P/119/13/NMA

Application for a non-material amendment following a grant of planning permission.

Application for a non-material amendment following a grant of planning permission P/76/13/ to change 1 No window shape from round to rectangular, lowering of 1 No window sill height and the addition of 2 No velux windows on roof west side for additional light in to main living space.

DRAWING TITLE:
**PROPOSED
ELEVATIONS**

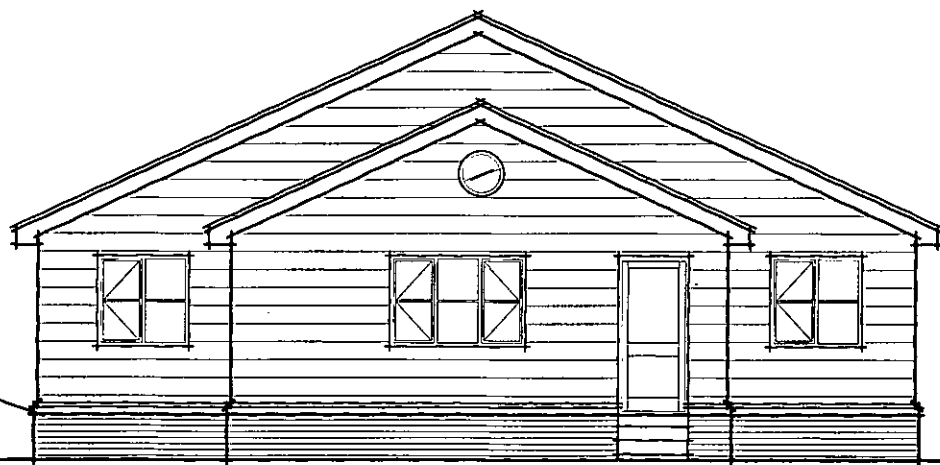
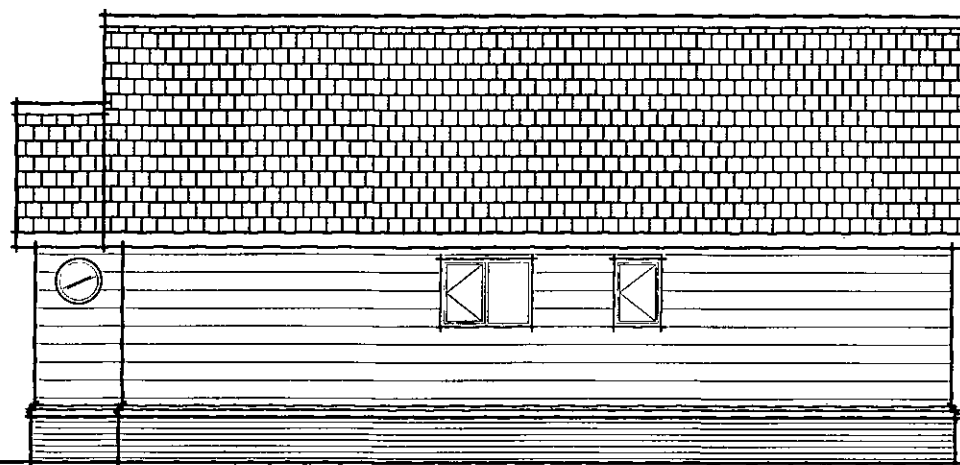
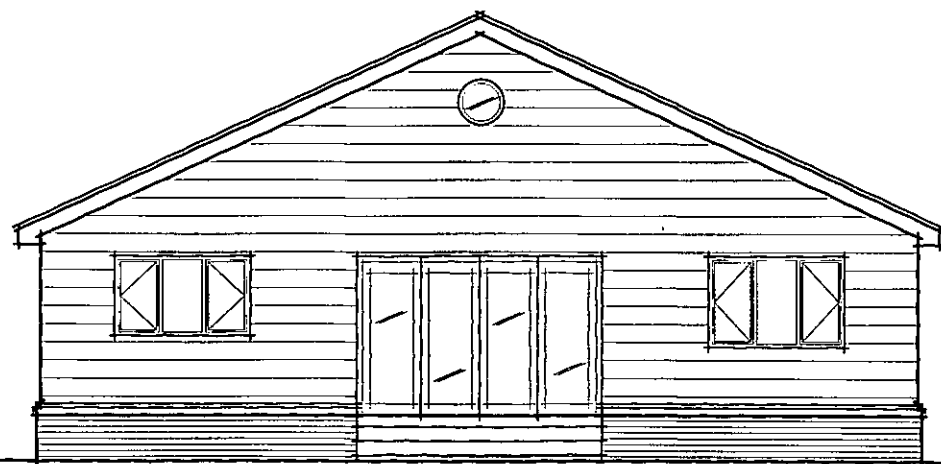
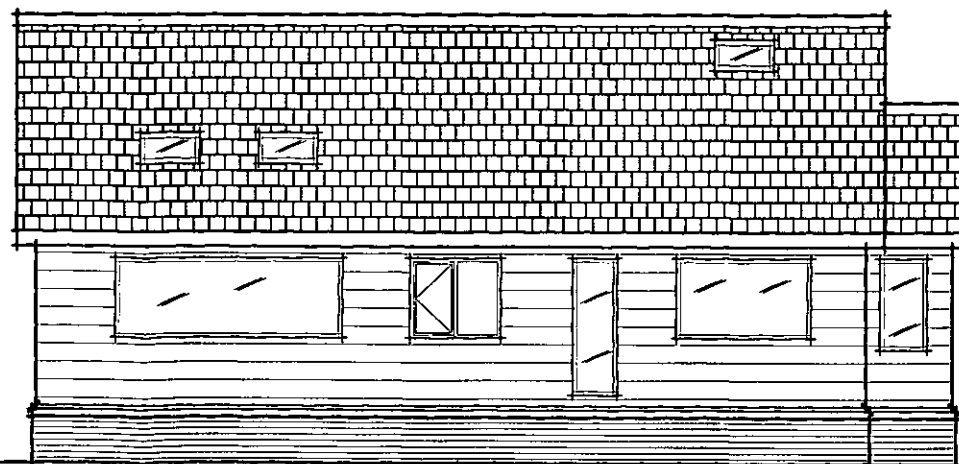
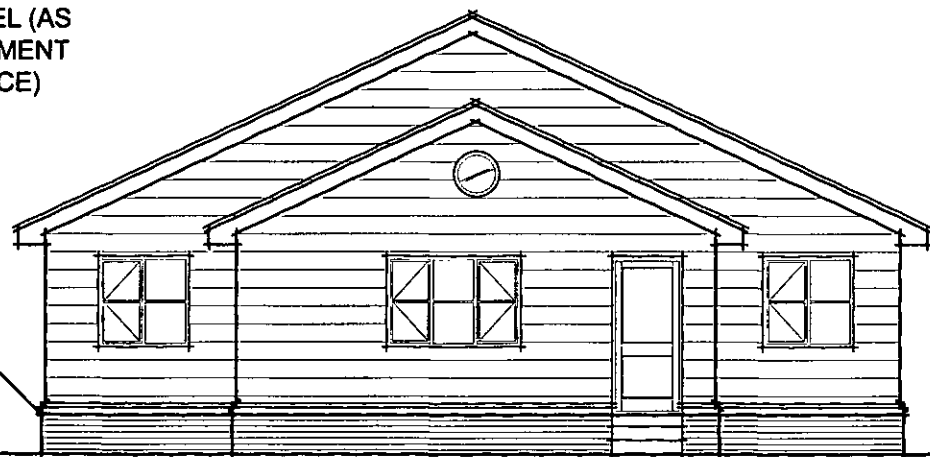
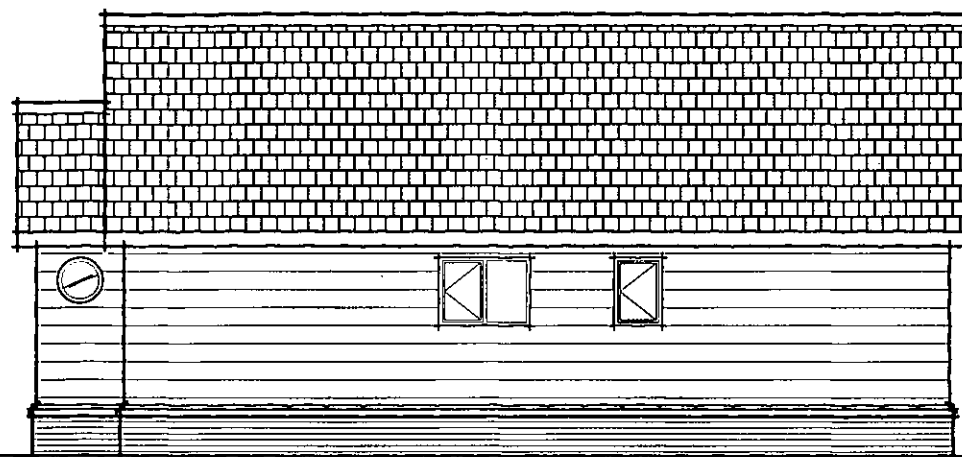
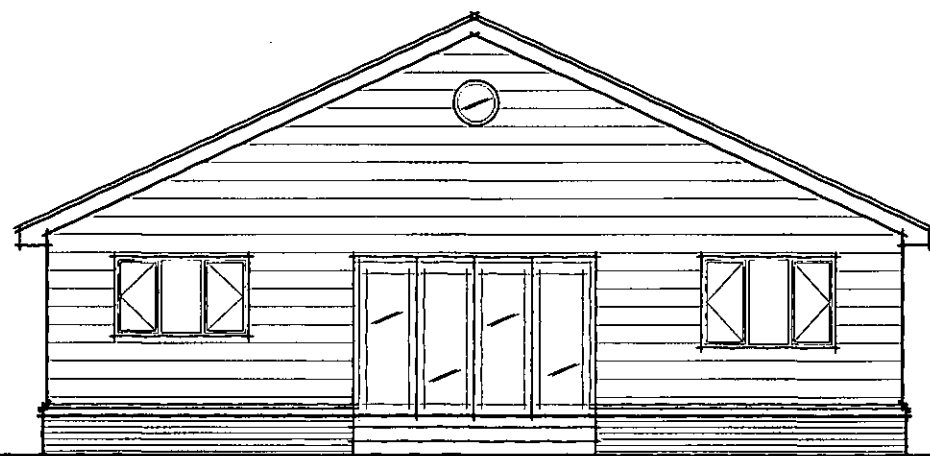
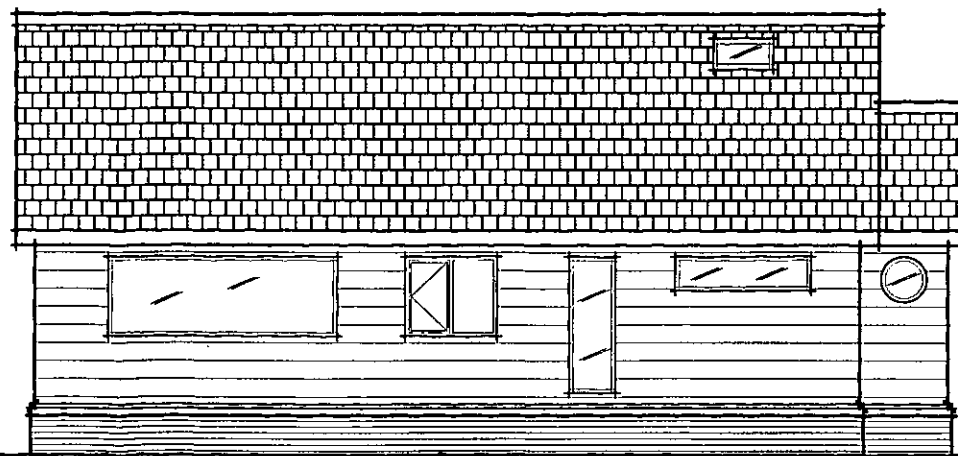
Please describe the non-material amendment(s) you are seeking to make:
① CHANGE OF 1 WINDOW SHAPE ^{ONLY} FROM ROUND TO RECTANGULAR
② LOWERING OF ONE WINDOW CILL ~~HEIGHT~~ HEIGHT TO A NORMAL WINDOW HEIGHT. WIDTH NOT AFFECTED.
③ ADDITIONAL 2 VELUX WINDOWS ON ROOF WEST SIDE FOR ADDITIONAL LIGHT INTO MAIN LIVING SPACE
NB: ALL WINDOW AMENDMENTS ARE ON THE WEST SIDE OF THE BUILDING WHICH DOES NOT OUTLOOK ANYBODY.

If Yes, please complete the following:
Old plan/drawing number(s): ELEVATIONS
New plan/drawing number(s): BR 04.

Please state why you wish to make this amendment:
① TO IMPROVE AESTHETICS OF HOUSE
② TO MAKE MORE PRACTICAL WINDOW WITH A MORE FAMILIAR AND SIMPLER AESTHETIC INTERNALLY AND EXTERNALLY.
③ TO ADD EXTRA LIGHT INTO MAIN SPACE
